Appin Mine Groundwater Model Peer Review

This letter report provides a peer review of the updated 2022 groundwater modelling undertaken by SLR for the EP. Australasian Groundwater and Environmental Consultants Pty Ltd. (AGE) undertook this review at the request of South32 Limited (South32).

- Appin Mine Extraction Plan. Groundwater Impact Assessment. SLR. V8.0. August 2022.

Figure 24 Modelled vs Observed Groundwater Levels

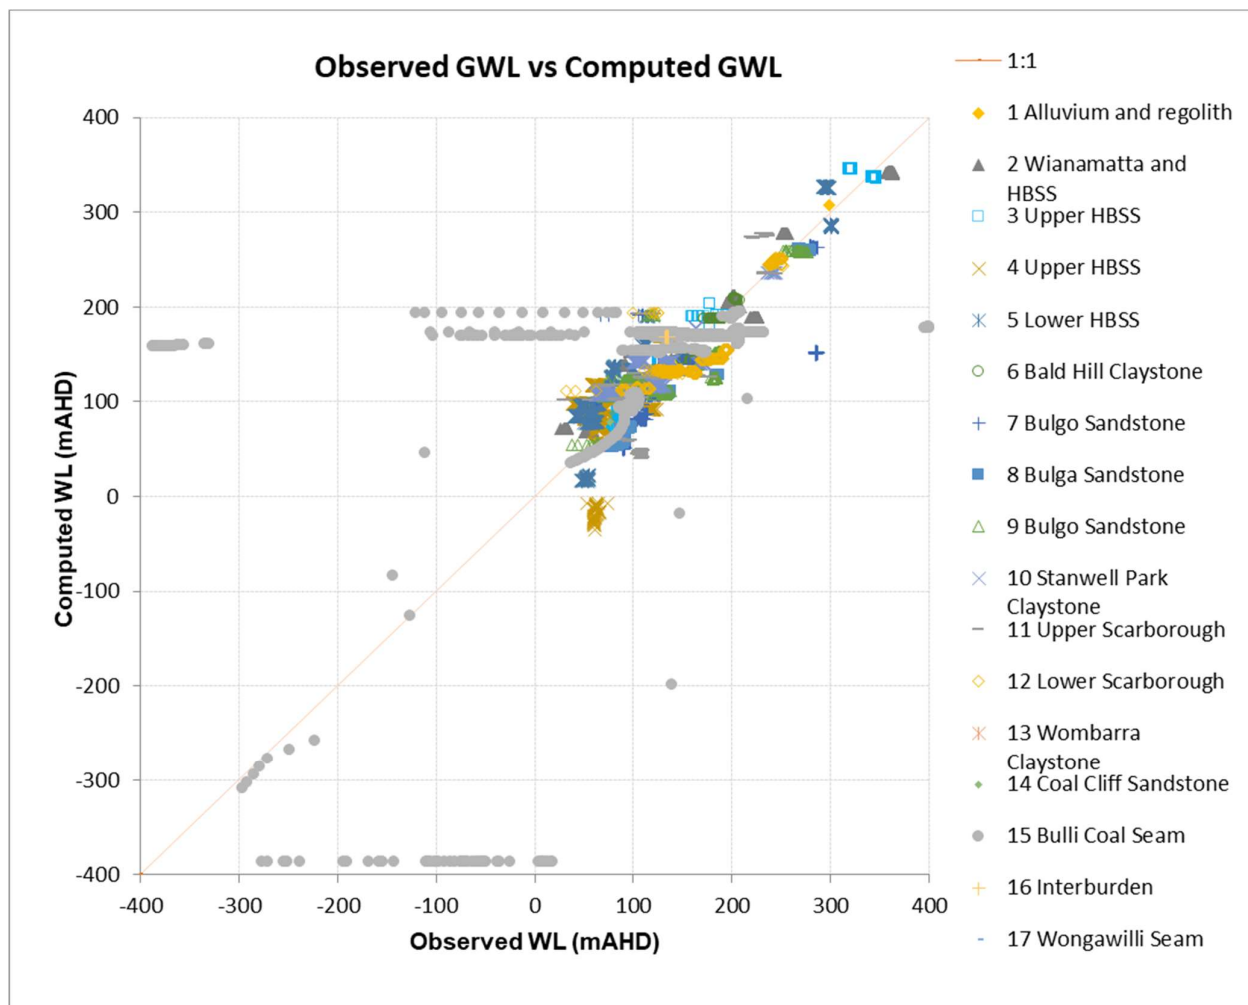
The scatterplots, RMS and SRMS statistics appear reasonable. The RMS and SRMS have reduced by approximately half compared to the 2009 modelling which represents an improvement. This is partly due to the extended range in the measurement set in the Bulli seam. There is no discussion on any observations that were removed from the measurement set during history matching. Some discussion on the rejection process would improve the understanding of the history matching process.

Figure 25 Map of Average Groundwater Level Residuals

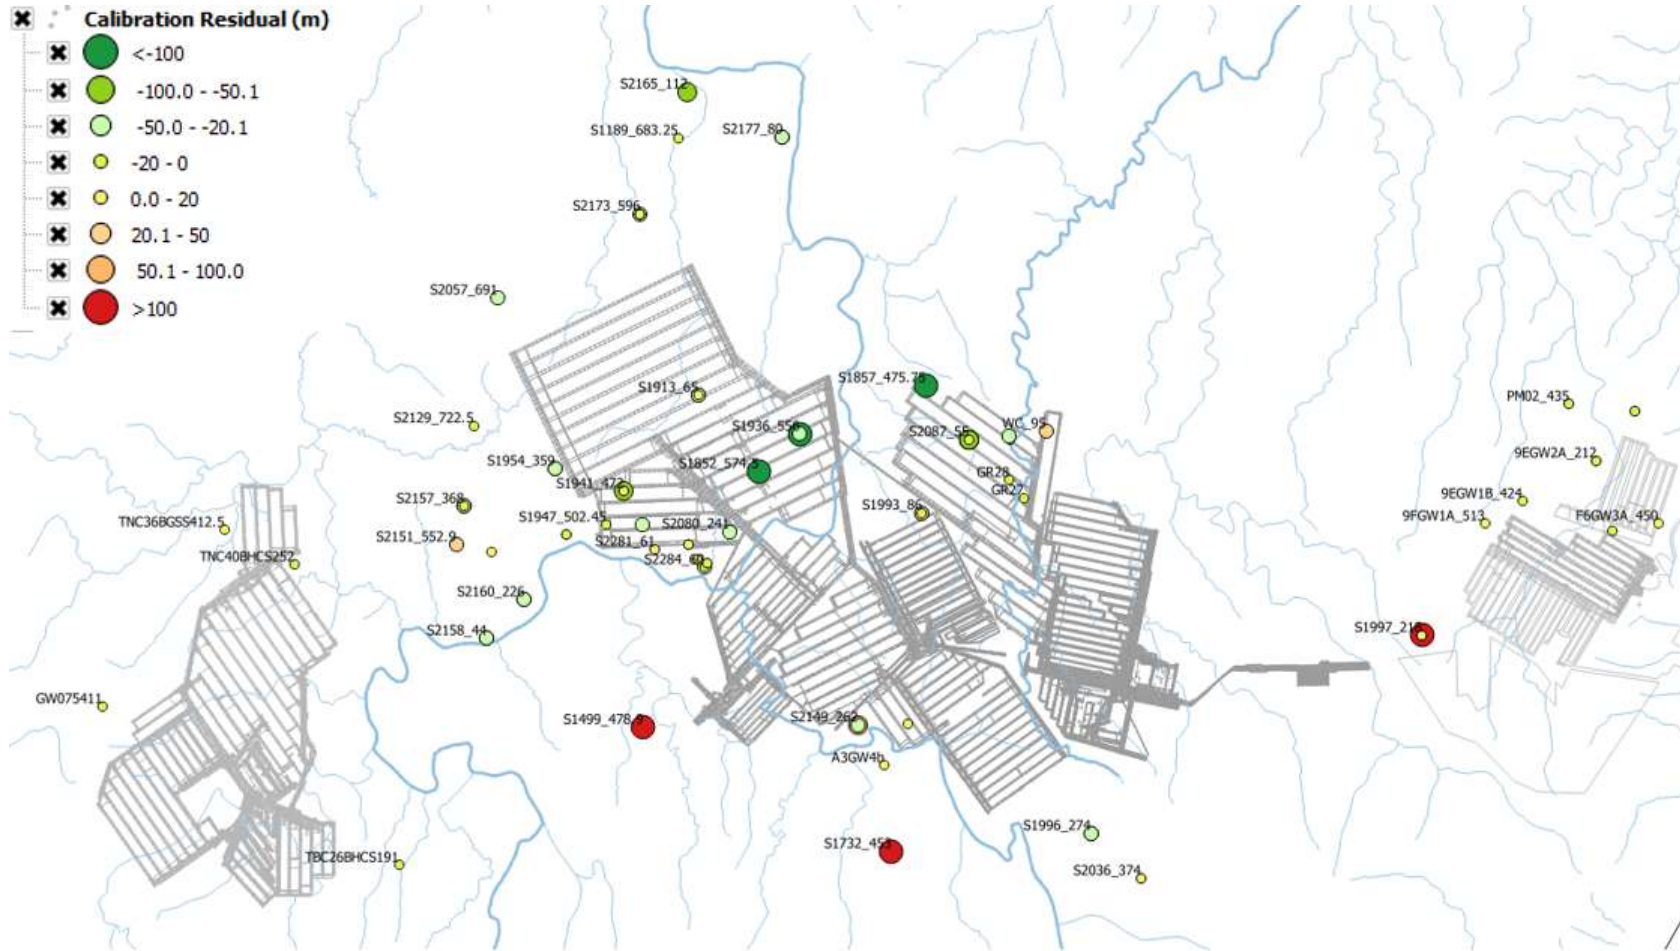
Spatial residuals in the pertinent aquifers/aquitards appear to be between about 10 m to 40 m around the Project area (it is difficult to interpret as the scale on the map is different to the legend). These residuals are primarily due to the models inability to simulate complicated dewatering mine processes and the lack of heterogeneity represented in the hydraulic properties. Vertical gradients are presented and discussed. These are generally well replicated by the model. Further calibration efforts could history match to these differences separately as well as absolute values of heads. This makes vertical hydraulic conductivity more estimable.
